Reviewed For Code Compliance By:
D. Banks Wallace
Chief Deputy Fire Marshal
12/03/2018 11:01:25 AM

TITLE/PROJECT INFO:
COVER SHEET - SITE PLAN
COBLE SKI SCHOOL
LILLINGTON, NC 27546

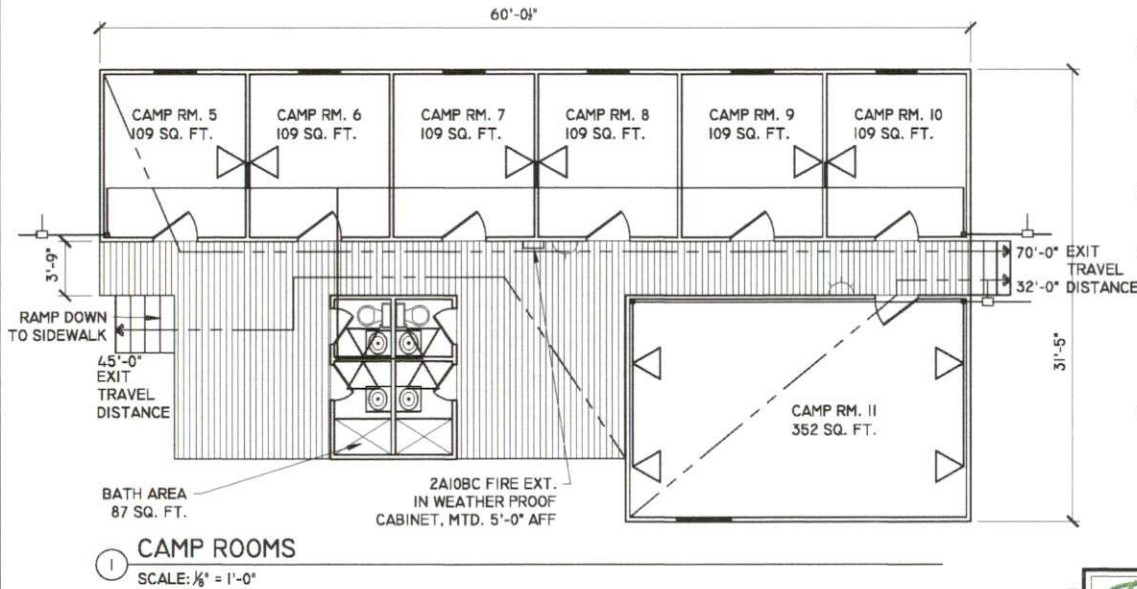
This space appears to meet the dormitory definition which would be 50 gross; 1004.2 deviation intent is based on standing room events, not sleeping arrangements.

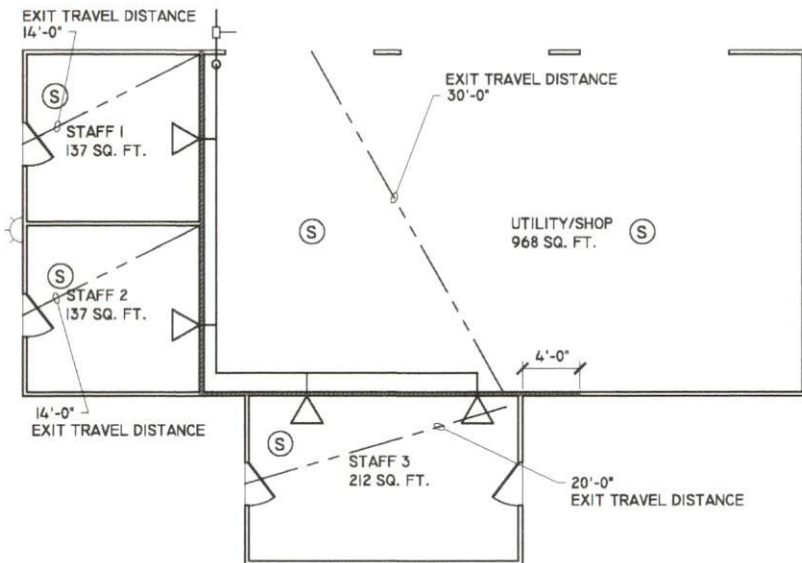
This space appears to meet the dormitory definition which would be 50 gross; 1004.2 deviation intent is based on standing room events, not sleeping arrangements.

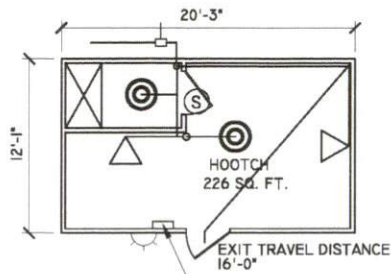
This space appears to meet the dormitory definition which would be 50 gross; 1004.2 deviation intent is based on standing room events, not sleeping arrangements.
